REQUEST

Current Zoning: CG (general commercial)
Proposed Zoning: MUDD-O (mixed use development district, optional)

Approximately 1.63 acres located along the northeast side of East 7th Street, south of Lamar Avenue, and north of Clement Avenue.

STAFF RECOMMENDATION

RZ2-00

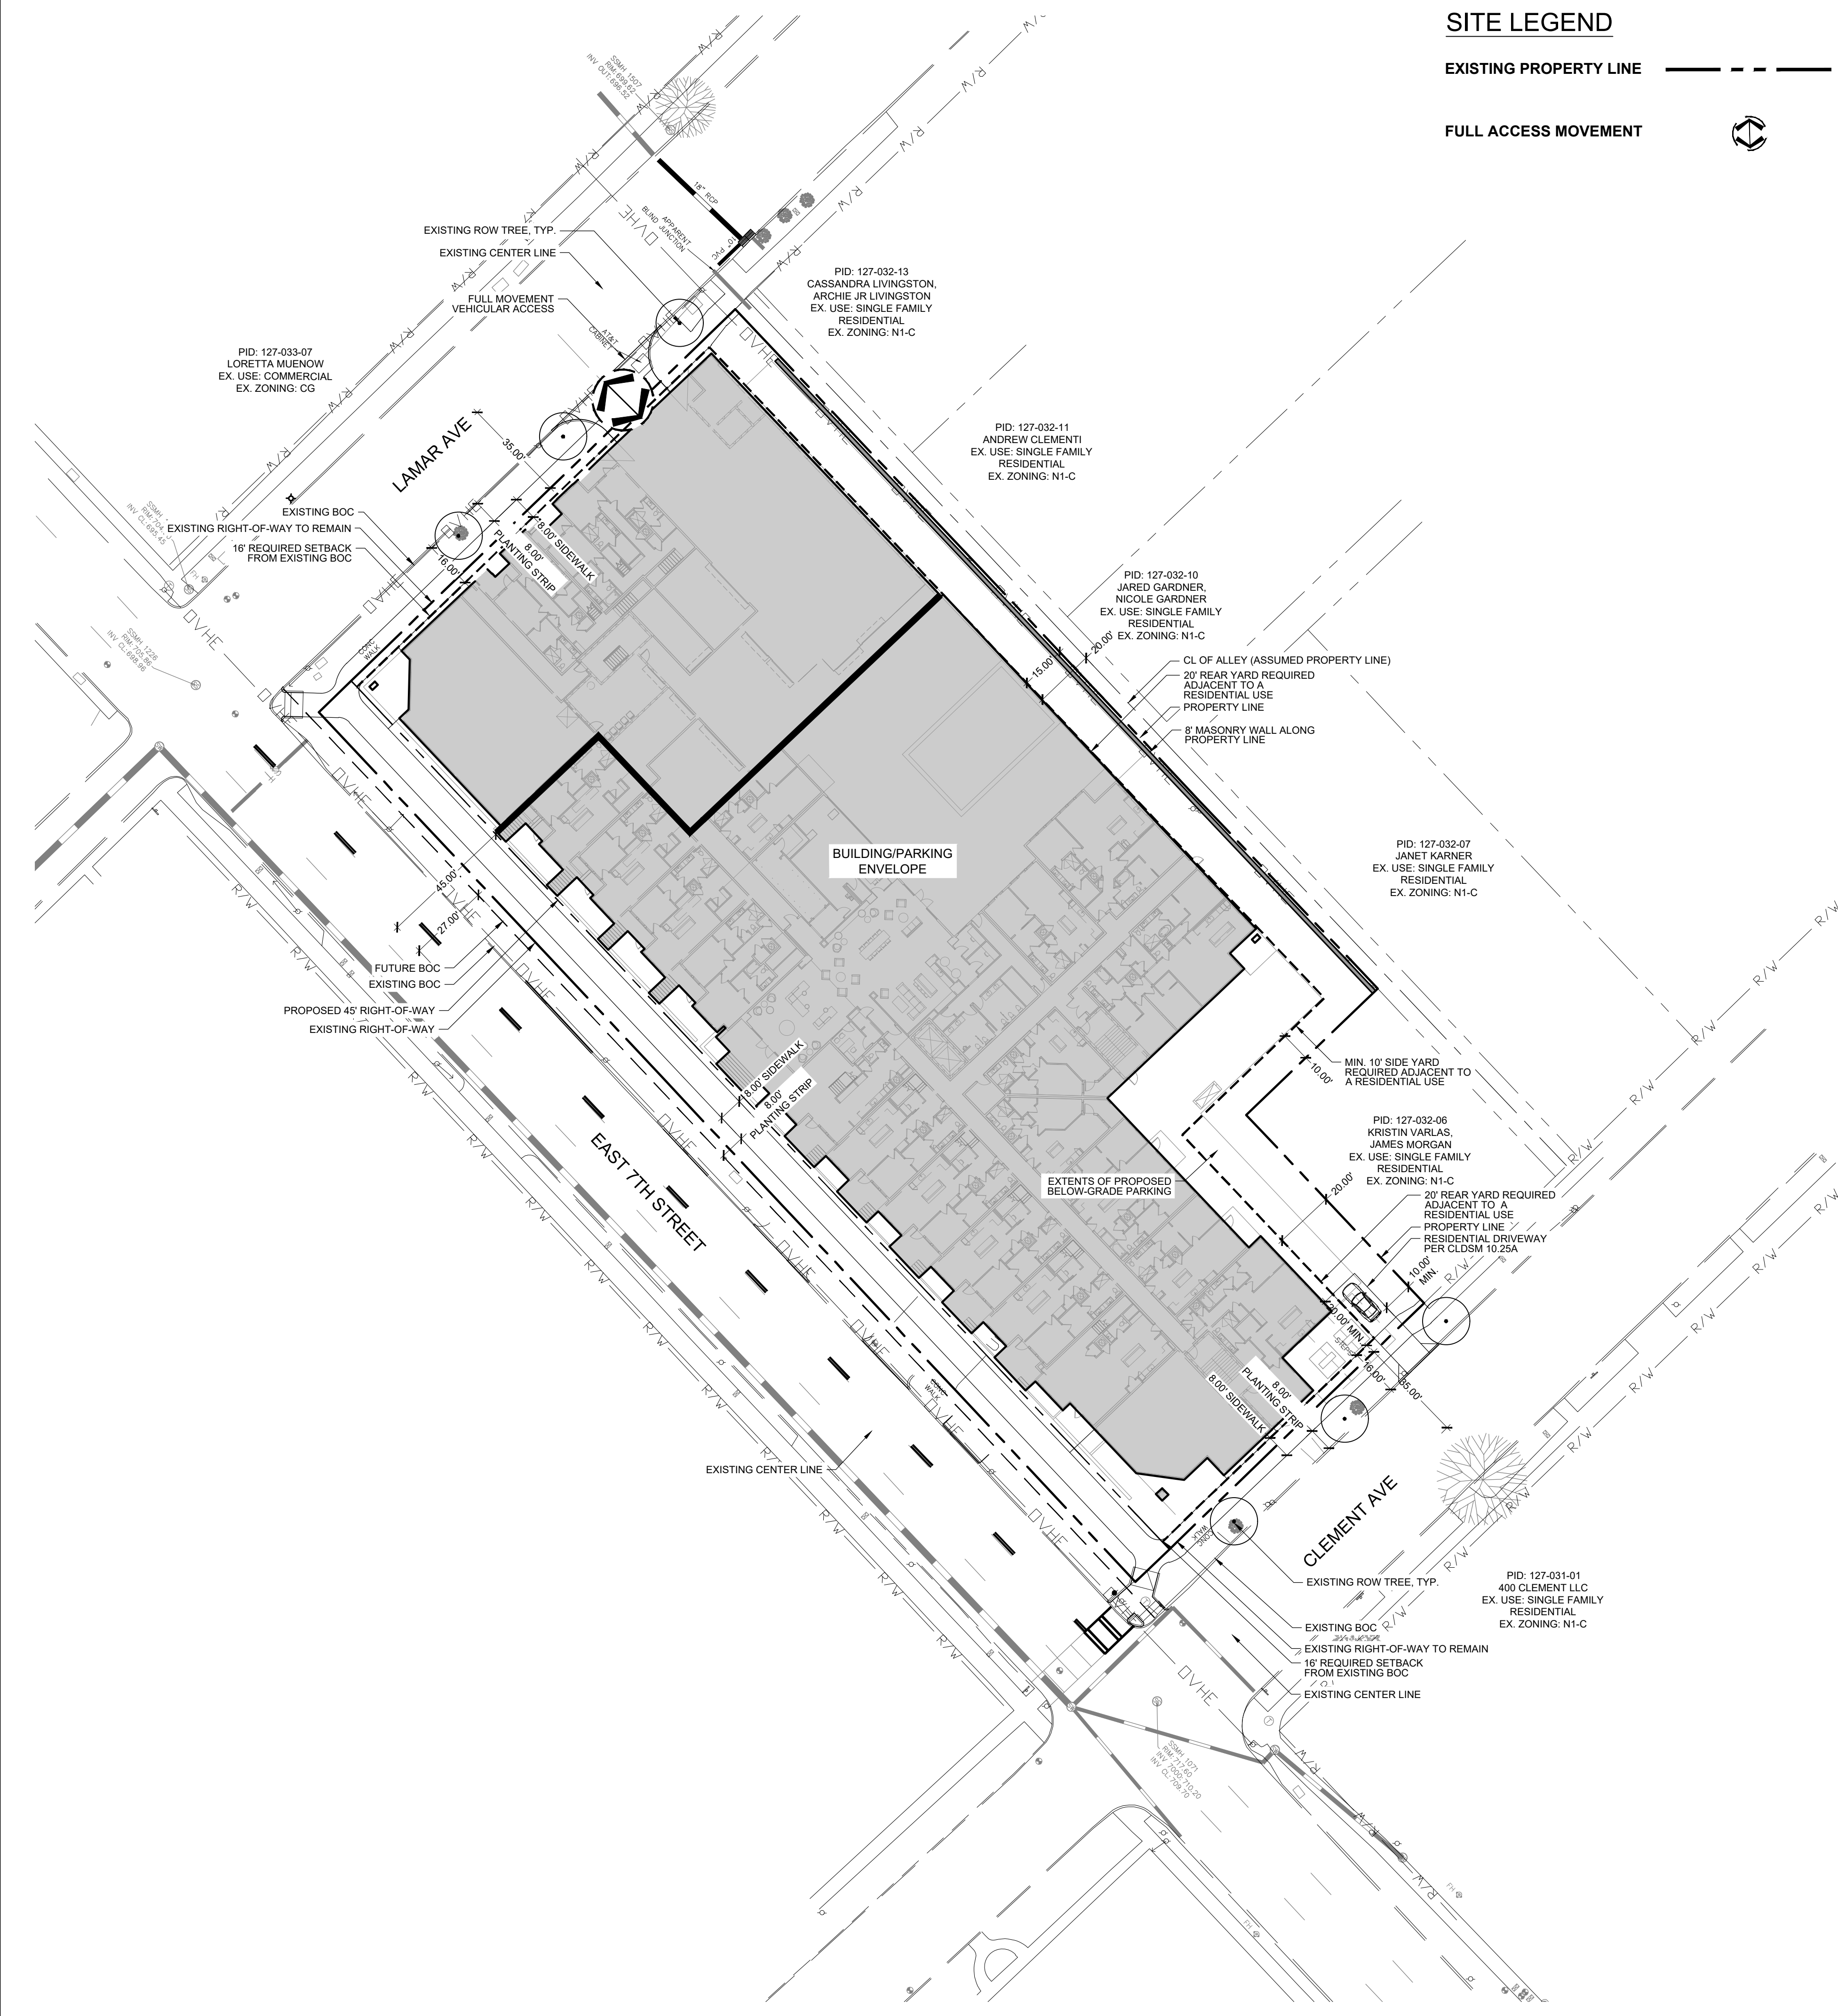
3. Modify the sidewalk and the 2' behind the sidewalk to be located within the ROW or sidewalk utility easement. If the existing ROW is remaining on Lamar and Clement Avenue, then add sidewalk utility easement to encapsulate the sidewalk plus the 2'.

4. Remove reference to conversion rights in maximum development section of the Site Development Data.
-

HEIGHT PLANE EXHIBITS

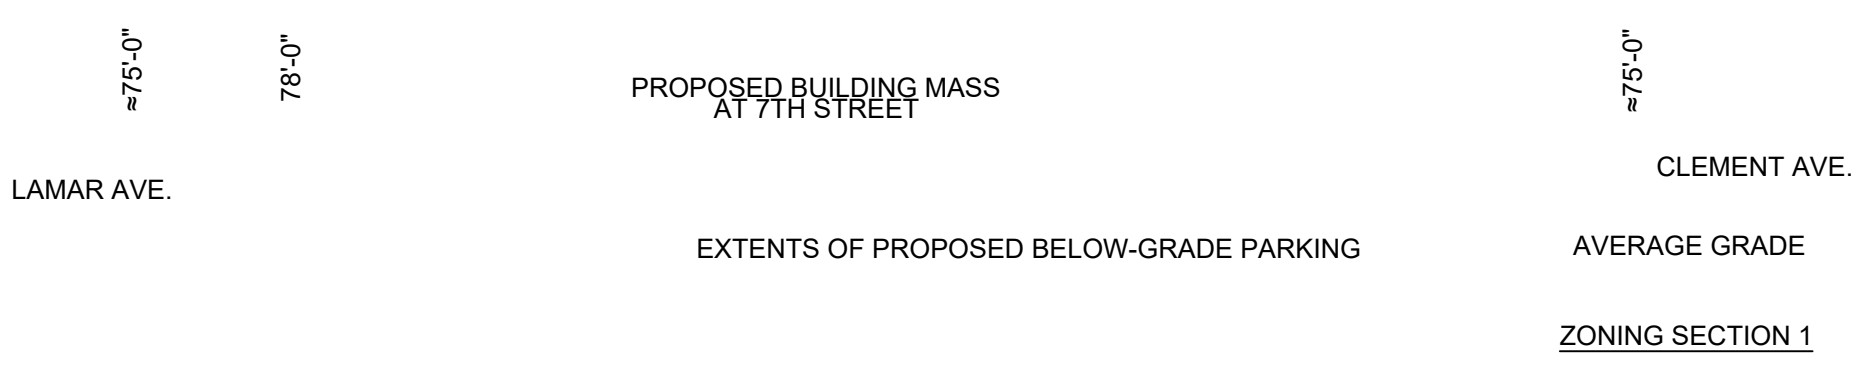
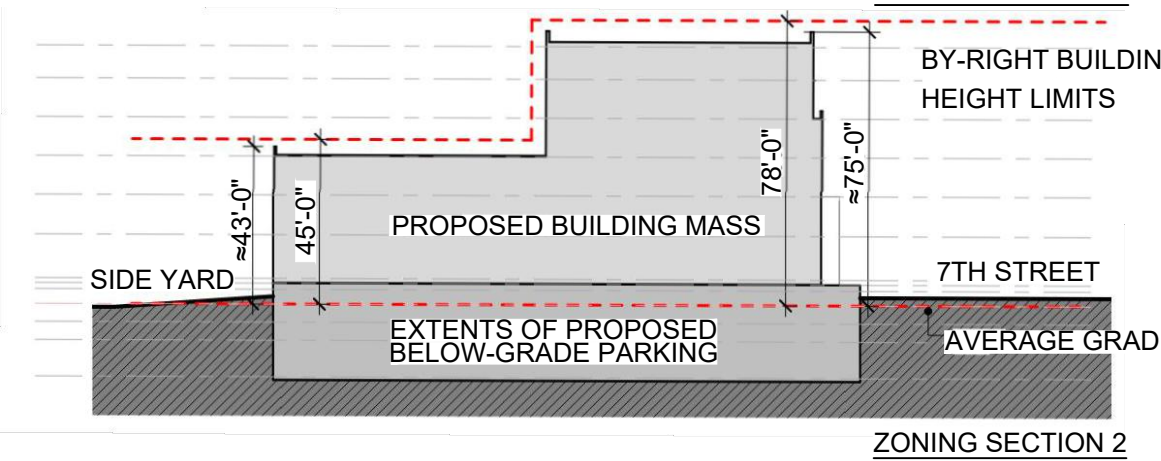
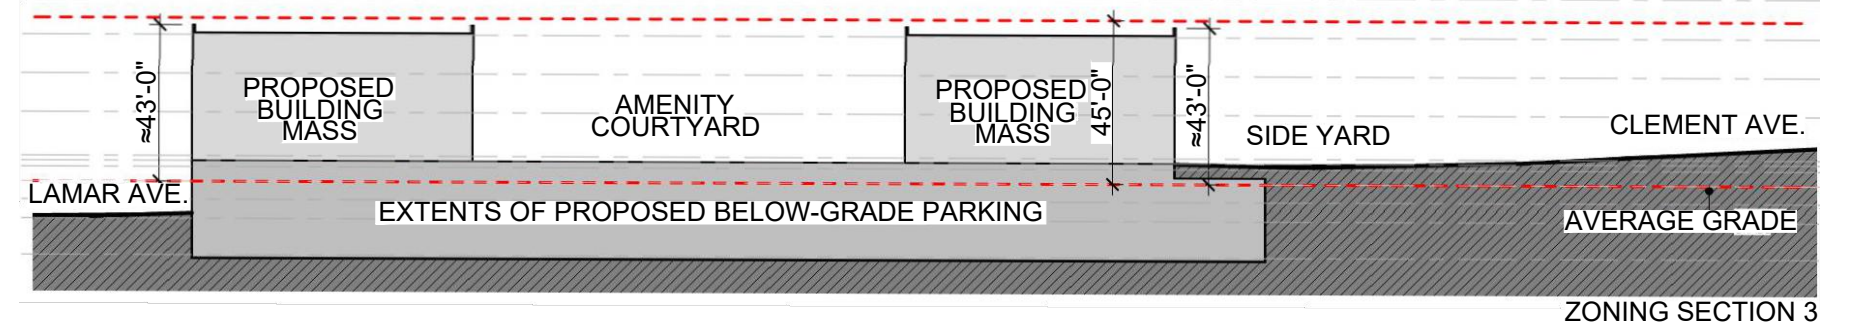
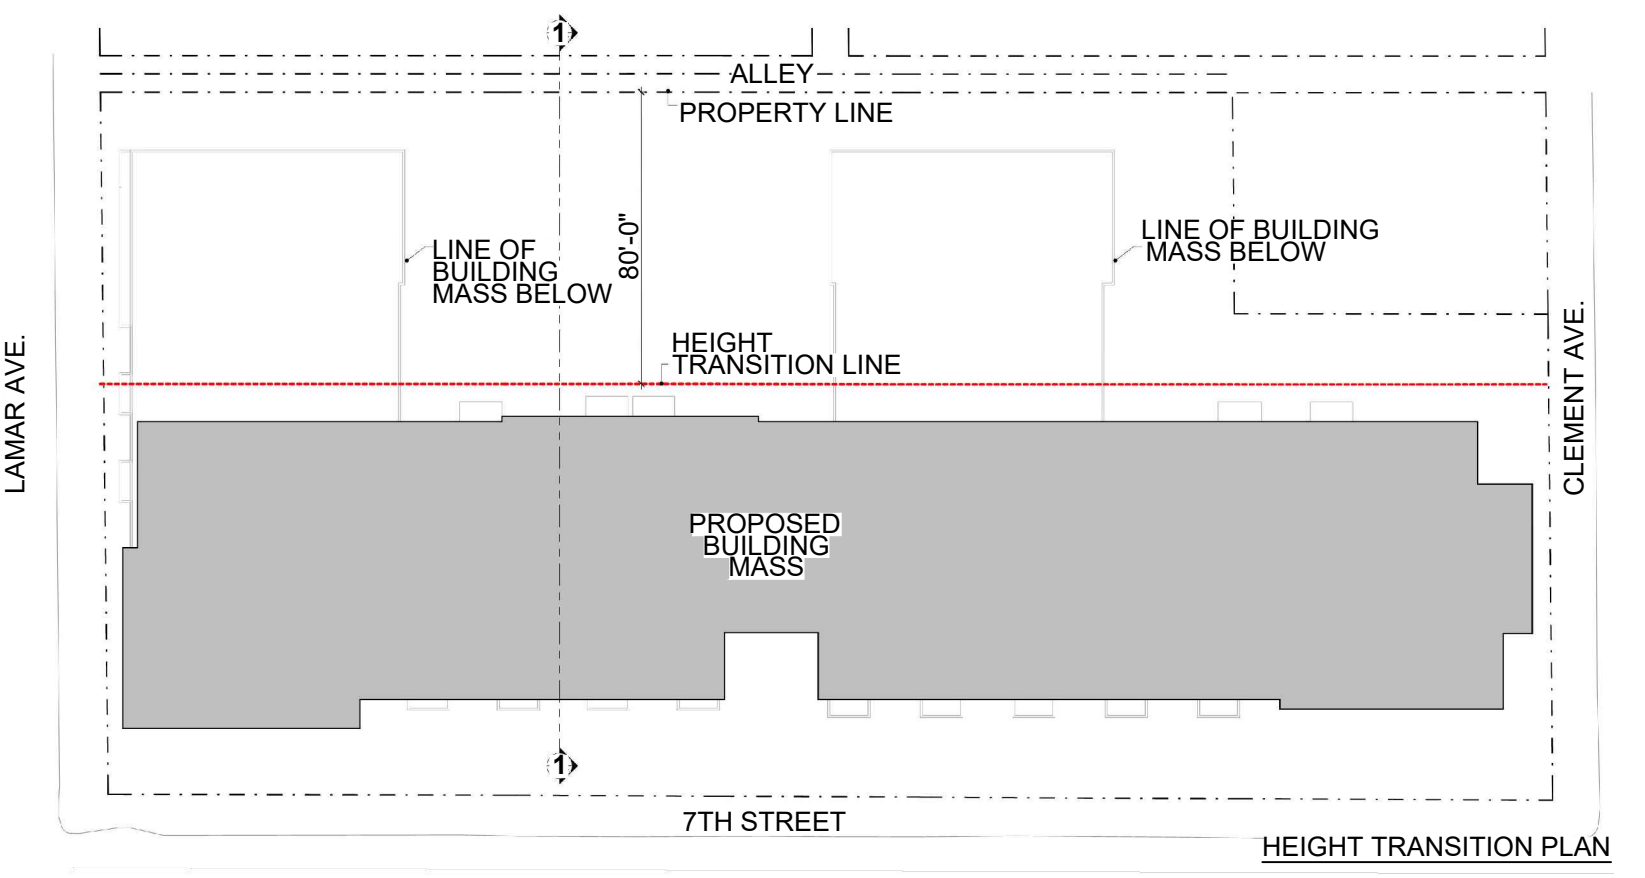
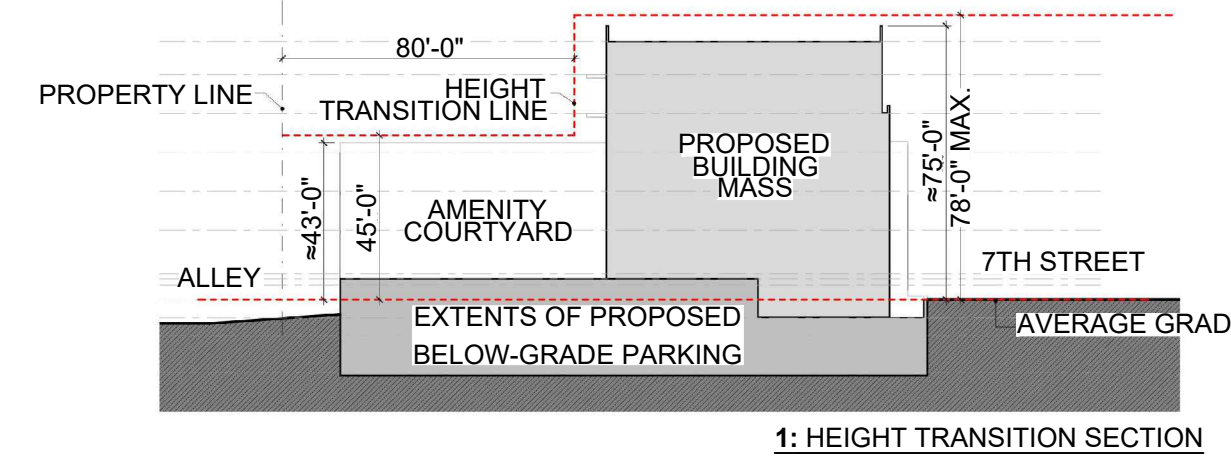
1. Reduce maximum building height to no more than 65' and detail in the conditional notes how the height steps down to the adjacent N1 areas by including a maximum height for the rear of the building and noting where the height stepdown occurs in terms of the number of feet away from the N1 areas.
